Harnett County

Permit Number: BRES2511-0013

Description: 38' x 15' Monoslope Covered Porch

LIST OF REVIEWS

REAR ELEVATION
SCALE: 1/4" = 1'0"

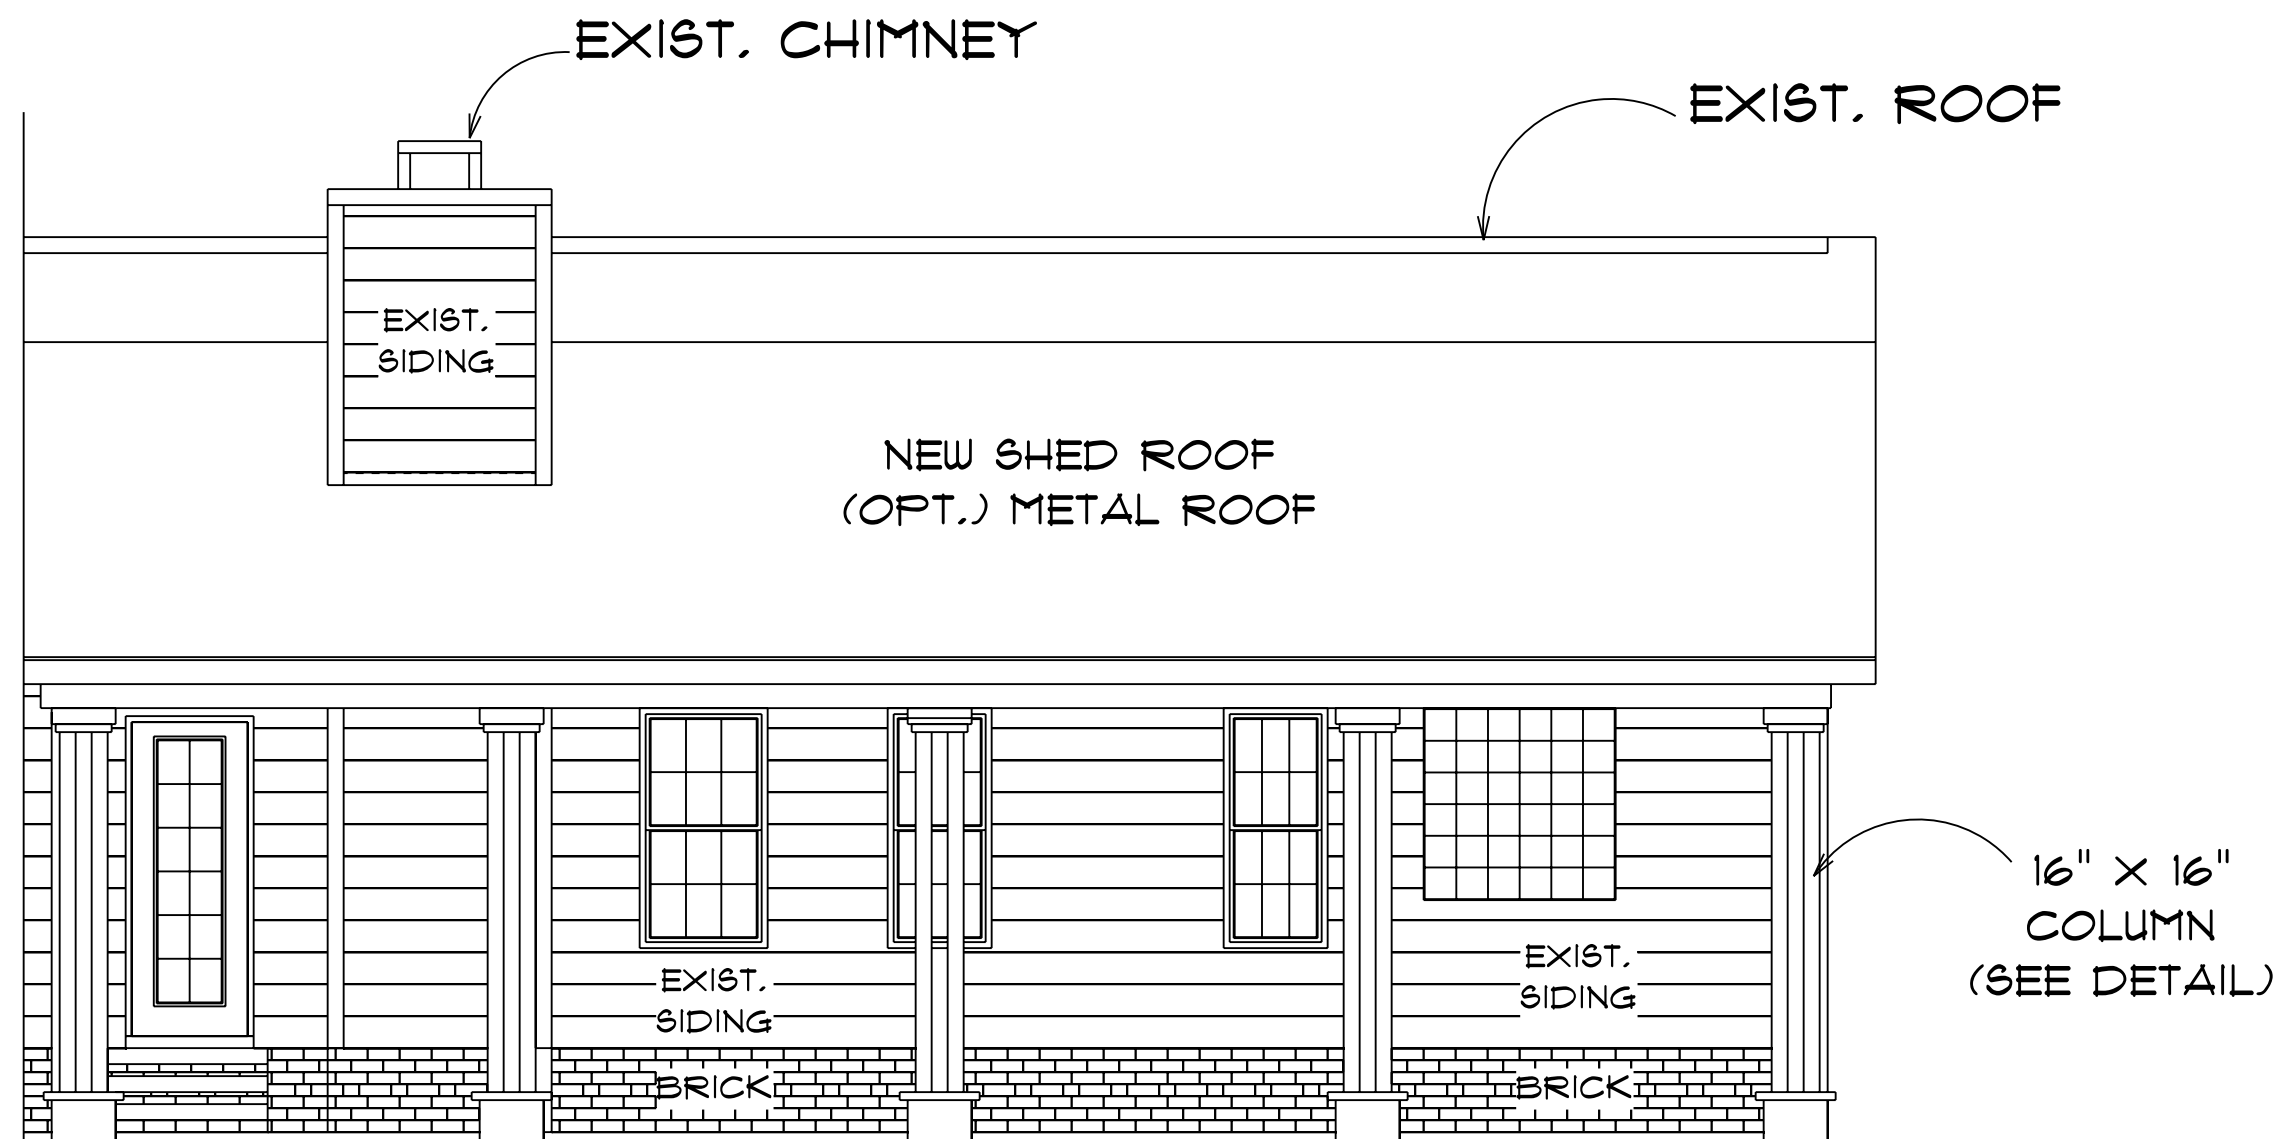
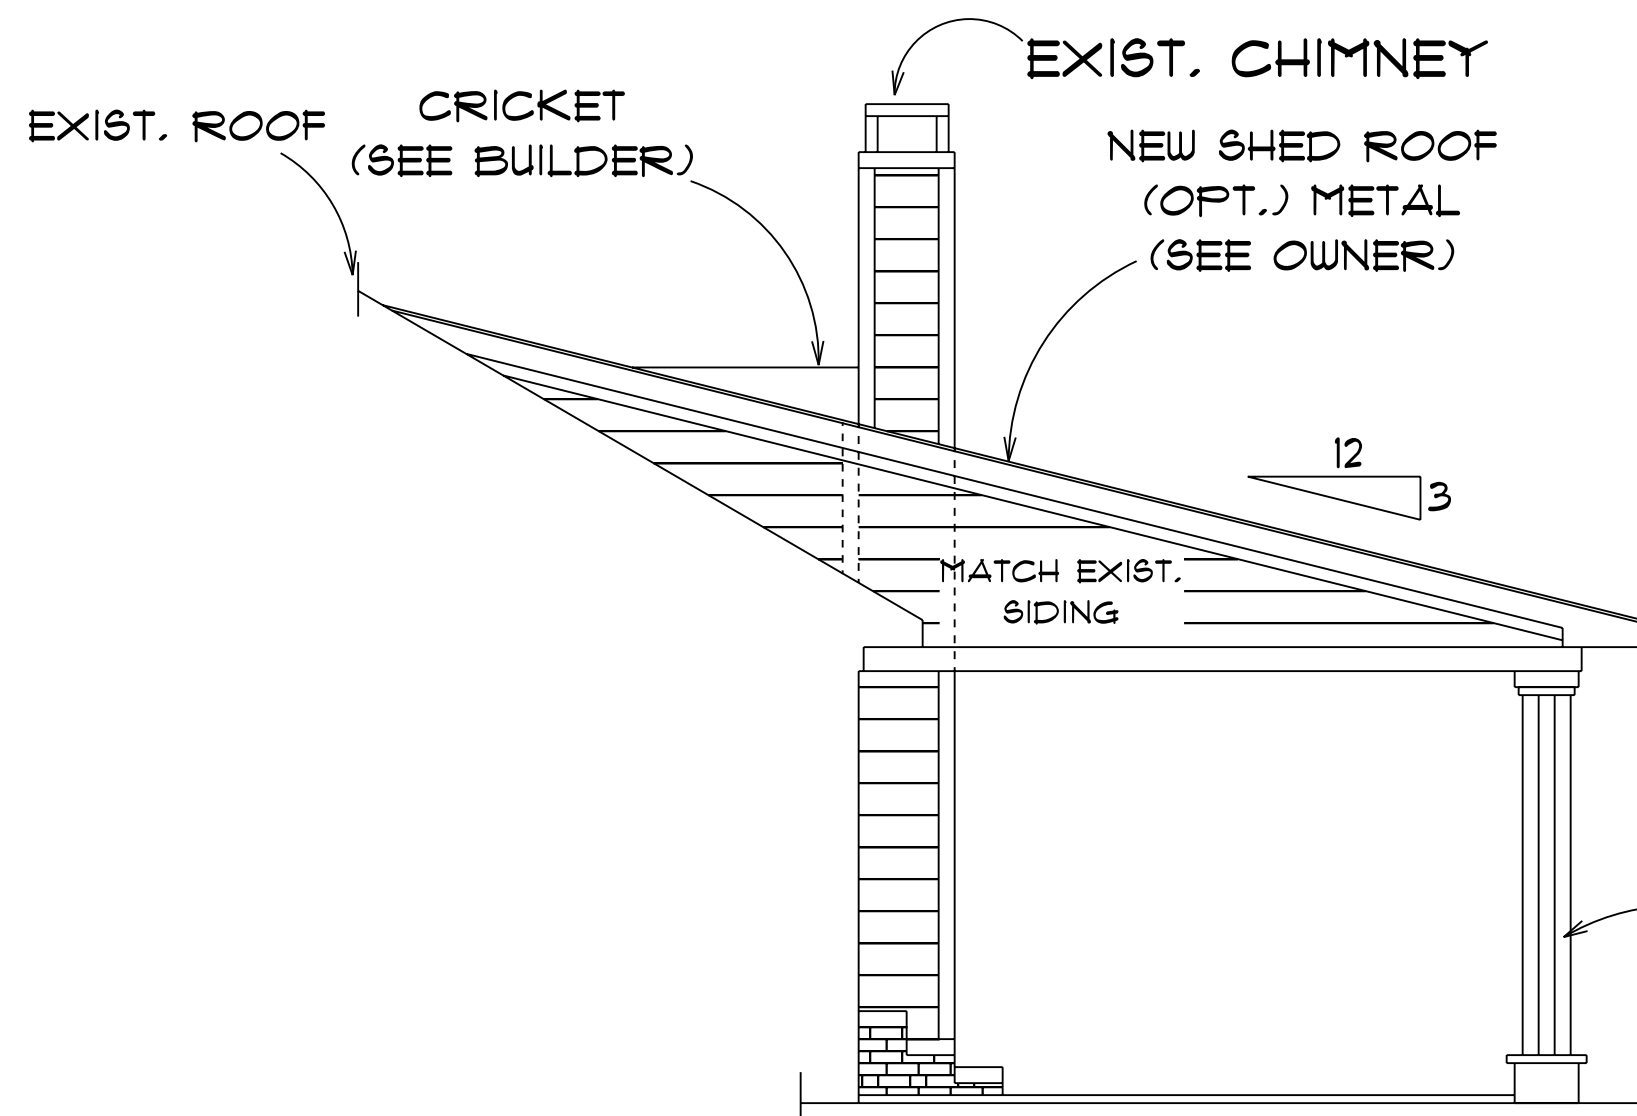
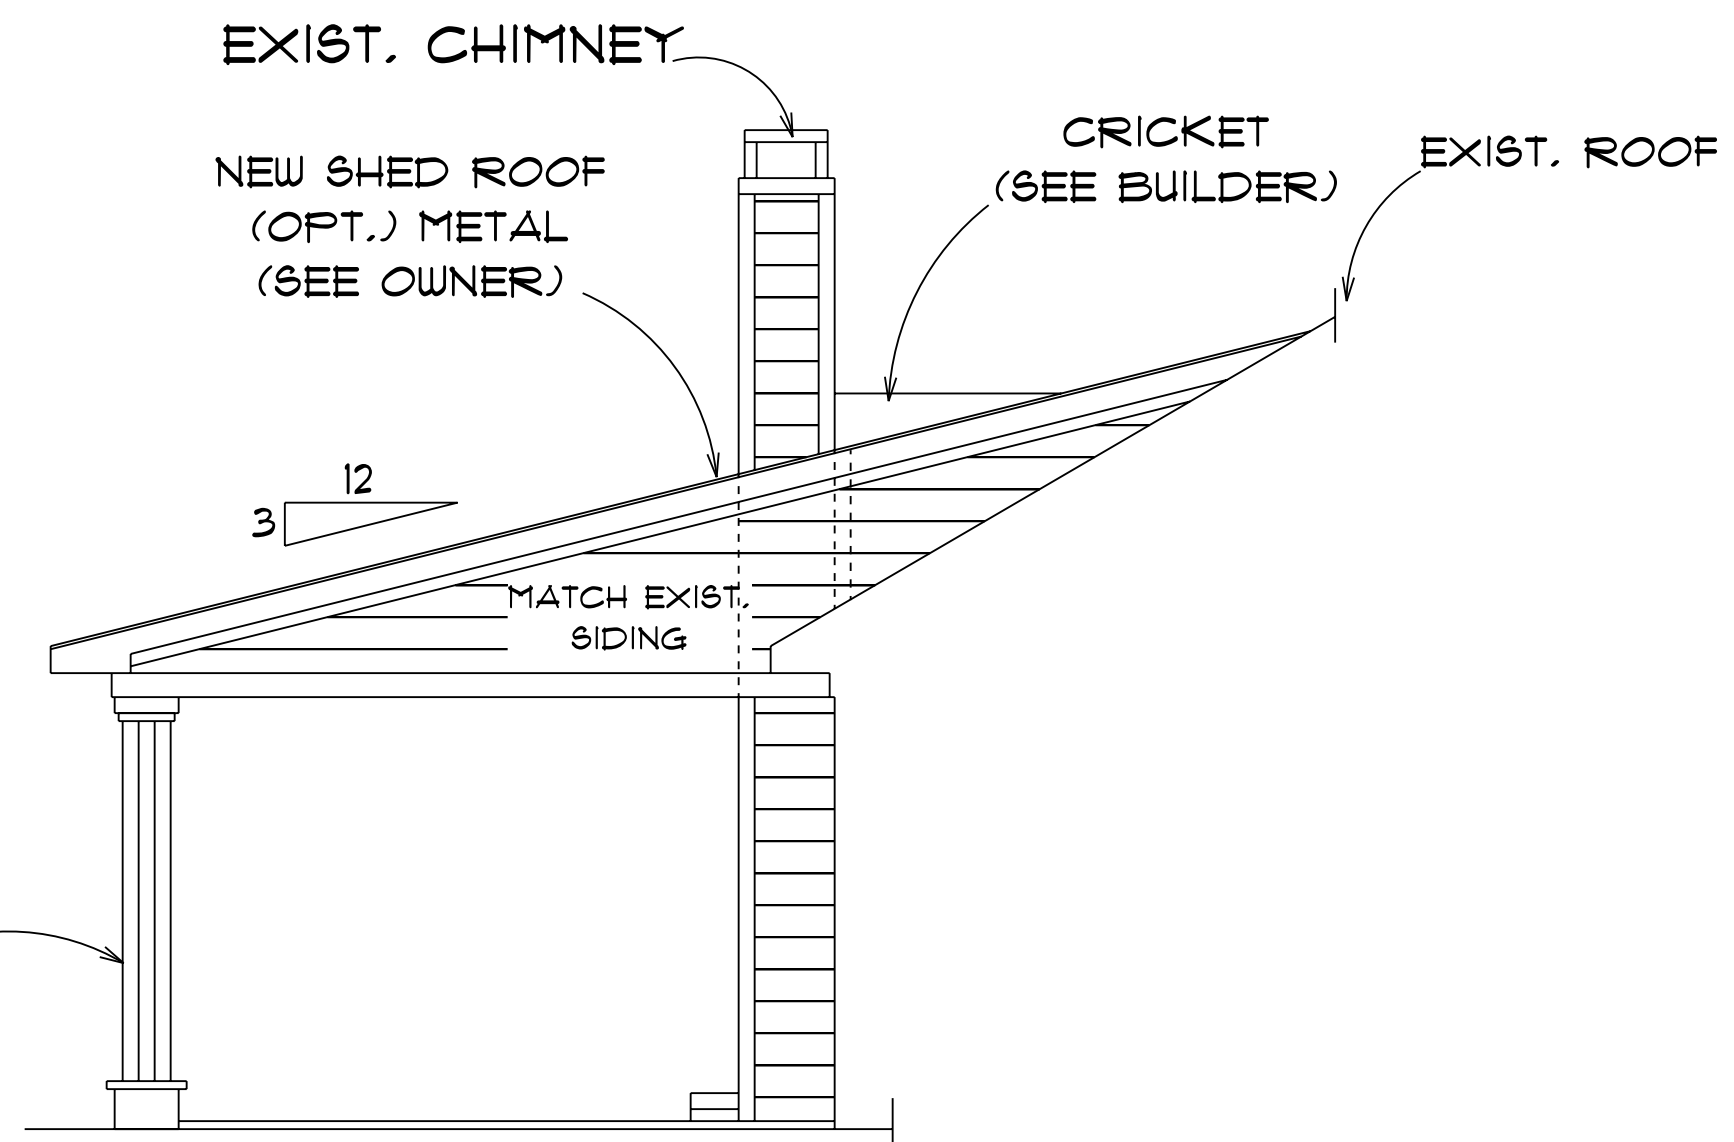
SENT DATE	RETURNED DATE	DUE DATE	TYPE	CONTACT	STATUS	REMARKS
Review Group: AUTO						
11/6/2025	11/6/2025	11/7/2025	CENTRAL PERMITTING INTAKE	CP Bucket	APPROVED	
Notes:						
11/6/2025	11/12/2025	11/12/2025	RESIDENTIAL BUILDING	Brad Sutton	DISAPPROVED	in attachments
Notes: 1. Need rafter size and spacing 2. Need ceiling joist size and spacing 3. Need roof beam size and posts to beam connection method.						
11/12/2025			RESIDENTIAL BUILDING	Building Bucket		
Notes:
